**RE: Letter of Intent  
Owl Marketplace Filing No. 1  
Parcel Nos. 5301001015**

Please accept this letter of intent and the enclosed supplemental material as Drexel, Barrell & Co's application and request for approval of the Vacate and Replate for Owl Marketplace Filing No. 1, on behalf of BH RE Investments, LLC to be developed as a four-lot commercial property. We request approval of this Vacate and Replat which has been prepared in accordance with El Paso County criteria.

# OWL MARKETPLACE FILING NO. 1

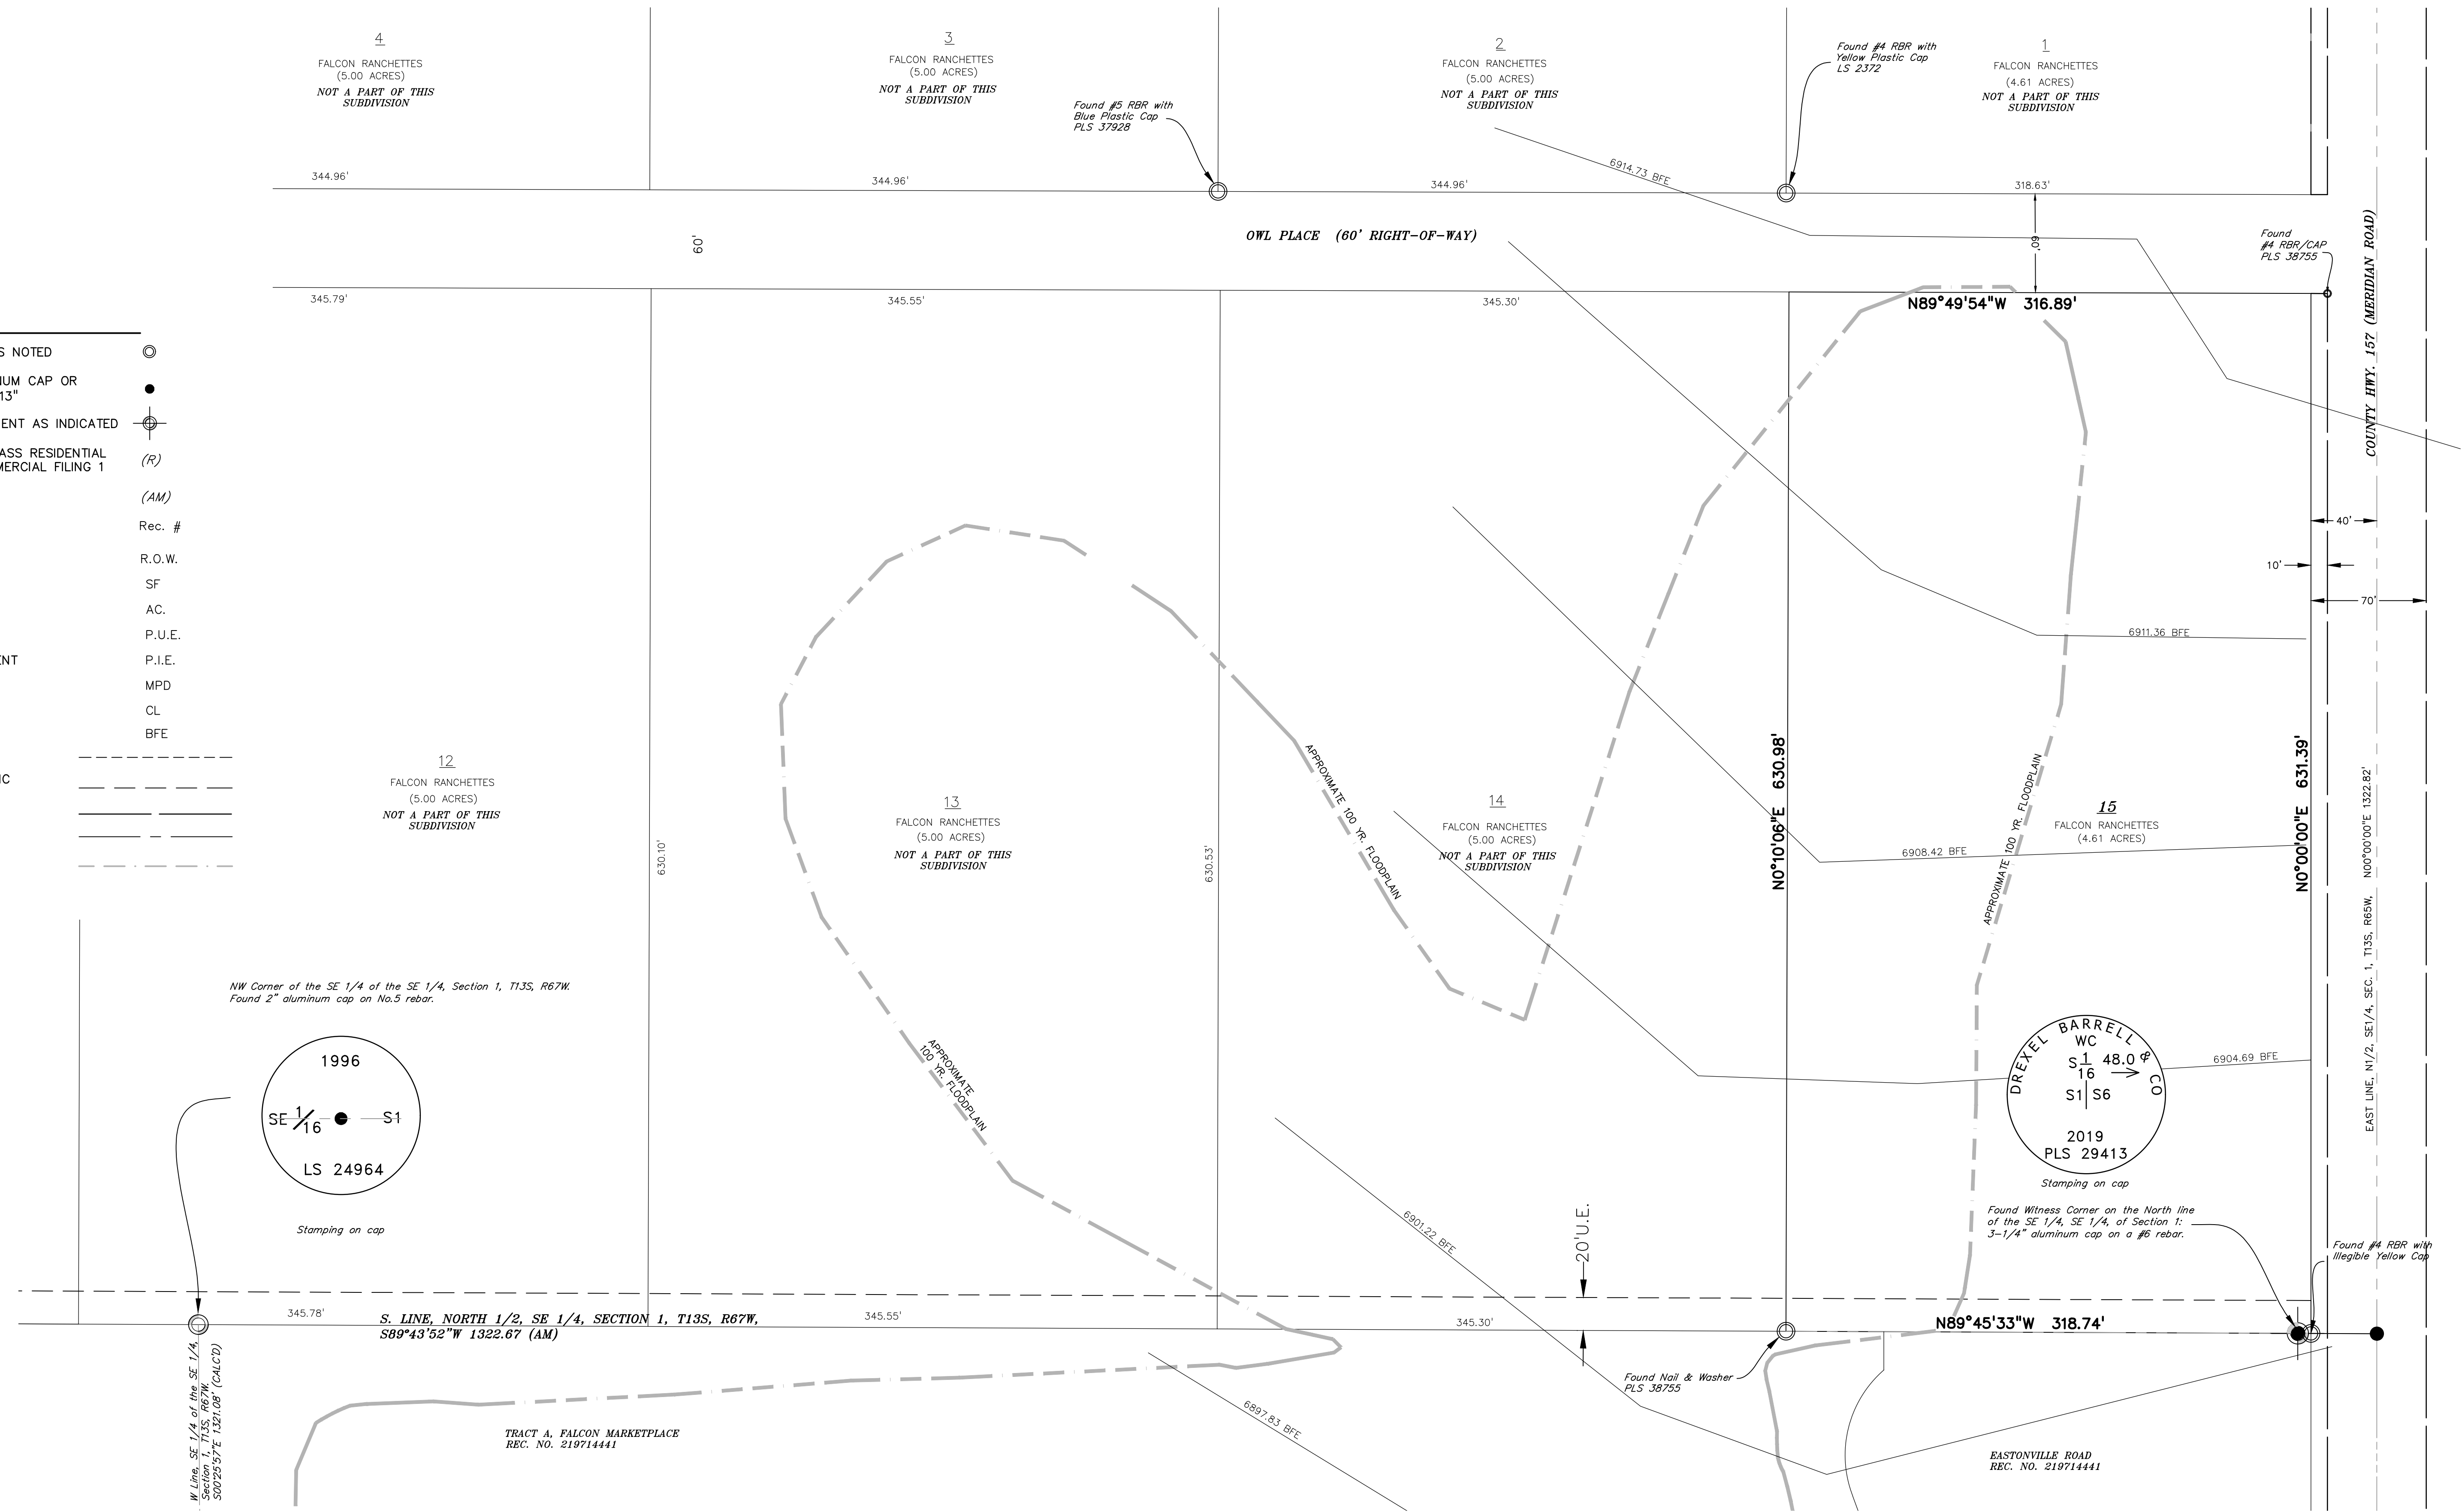
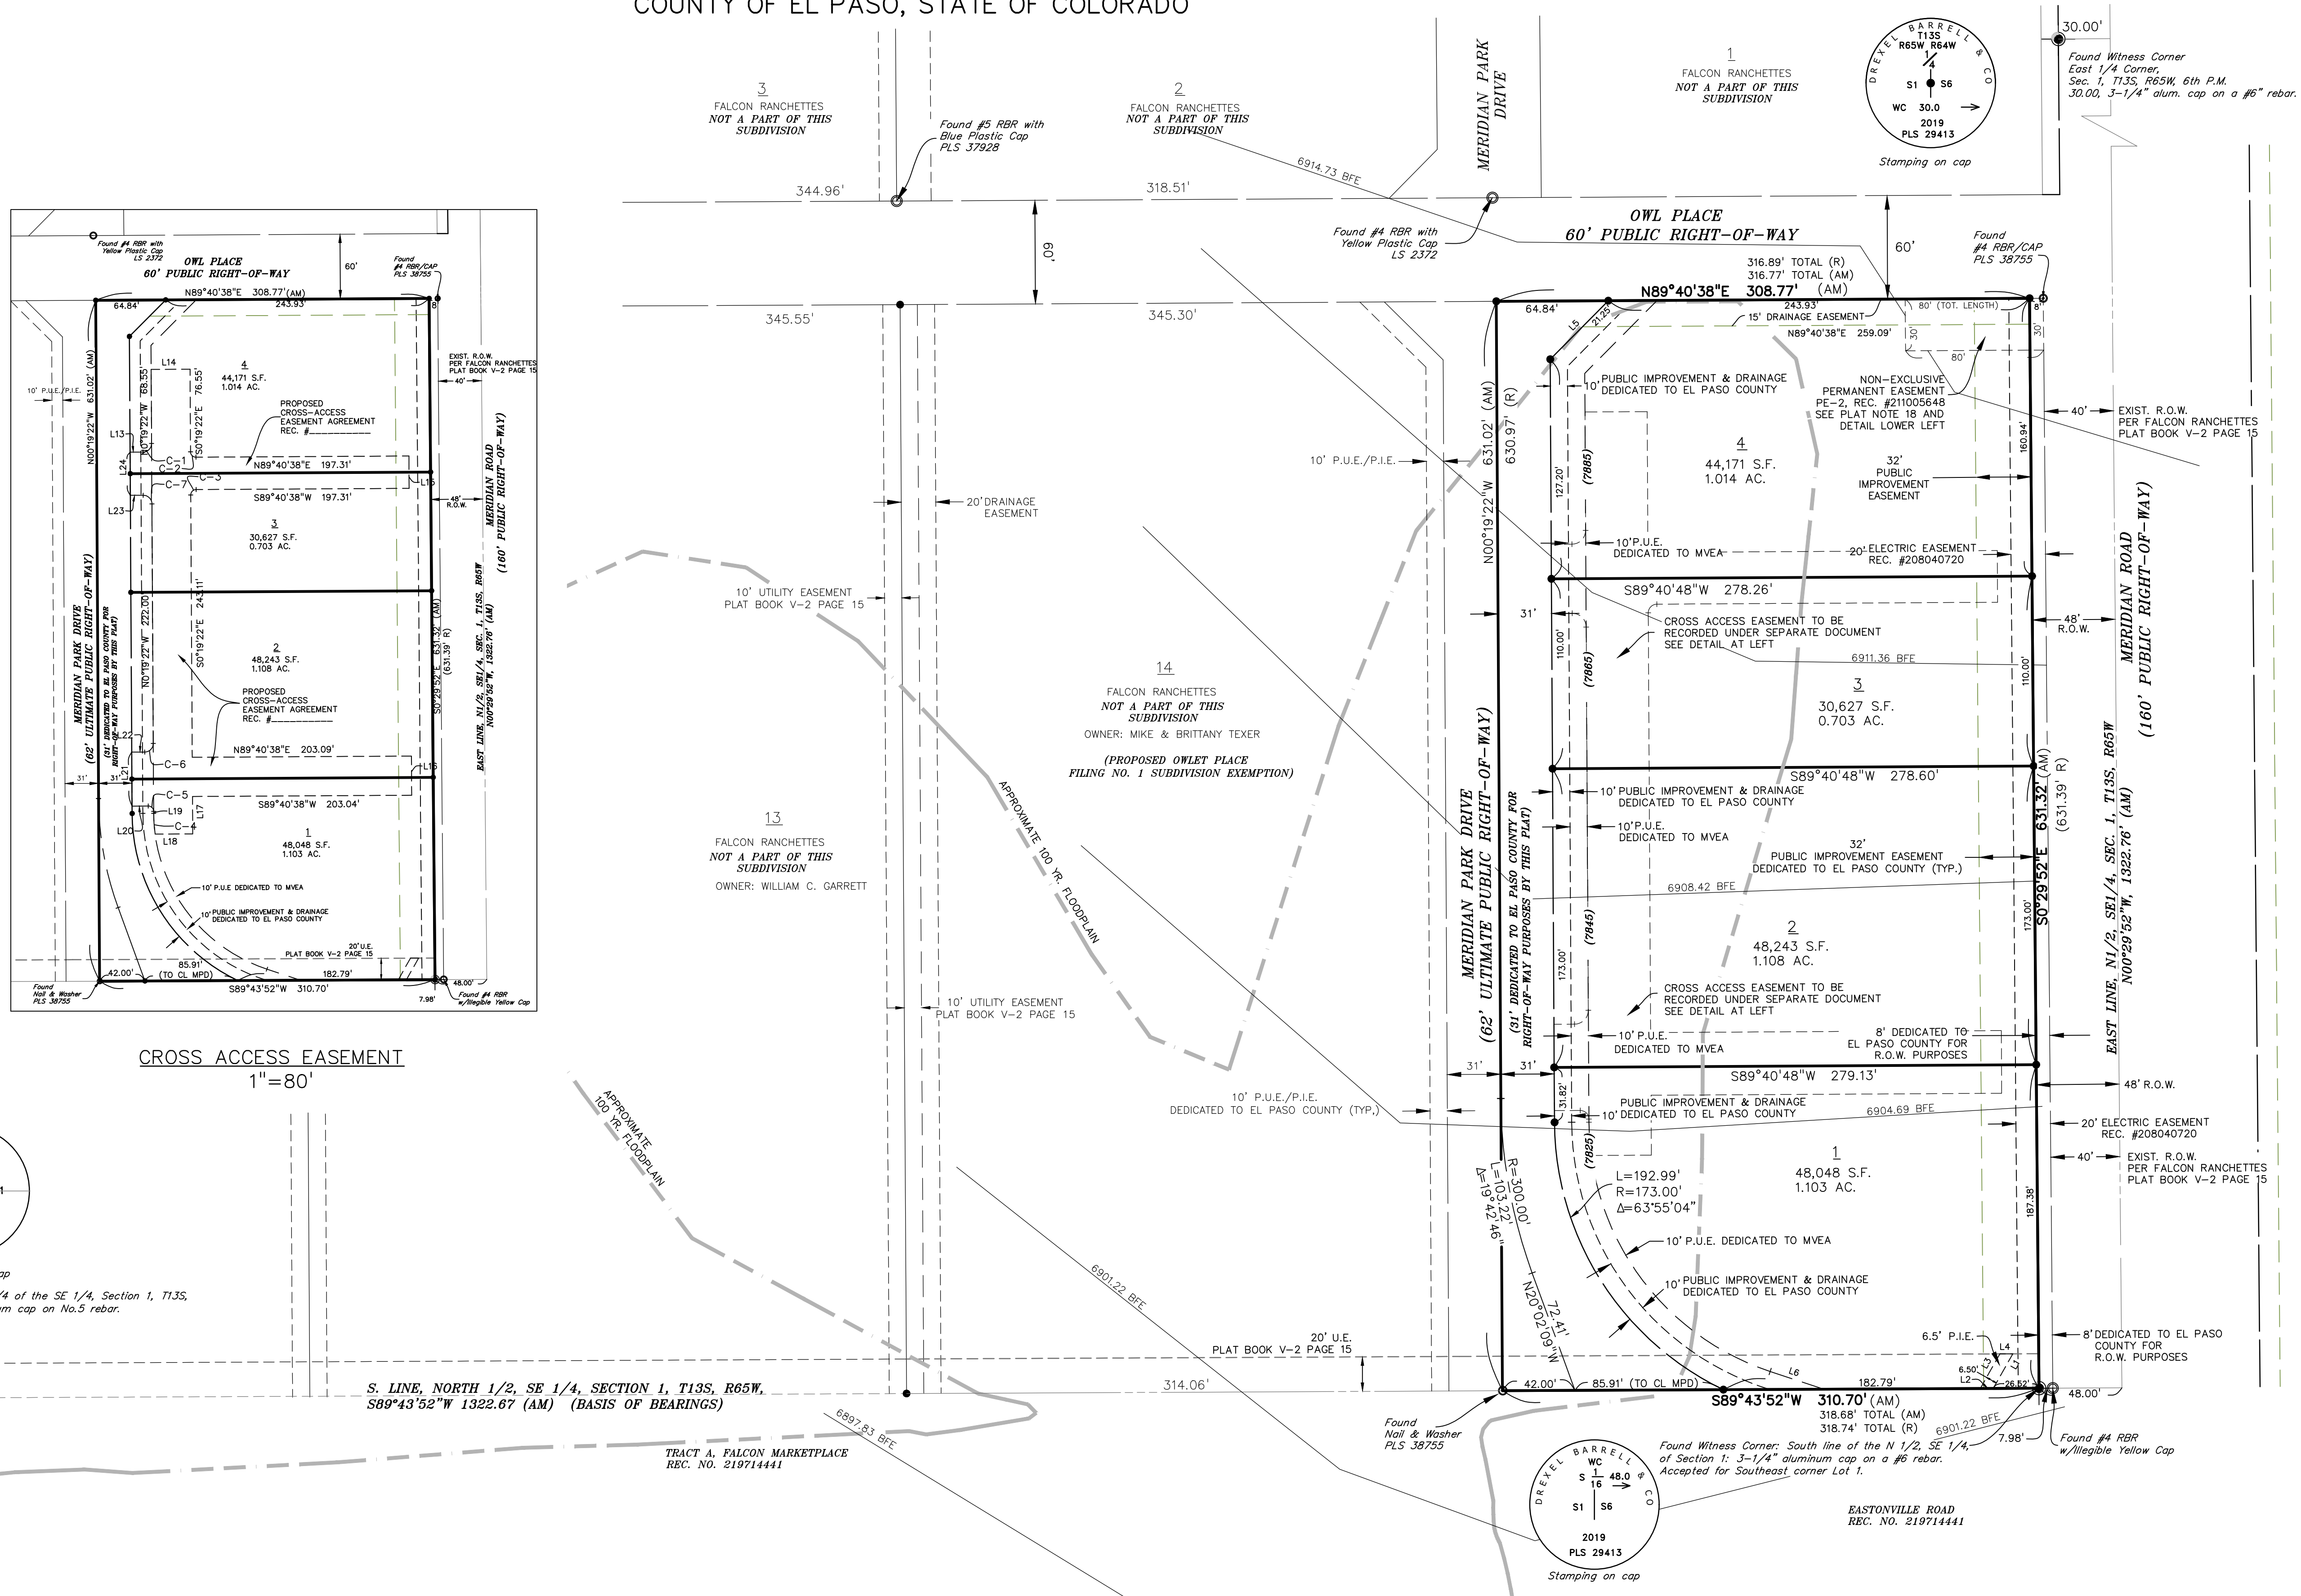
Include Lot 14 as shown in your plat

5? Include Lot 14

What will happen to the existing Lot 14
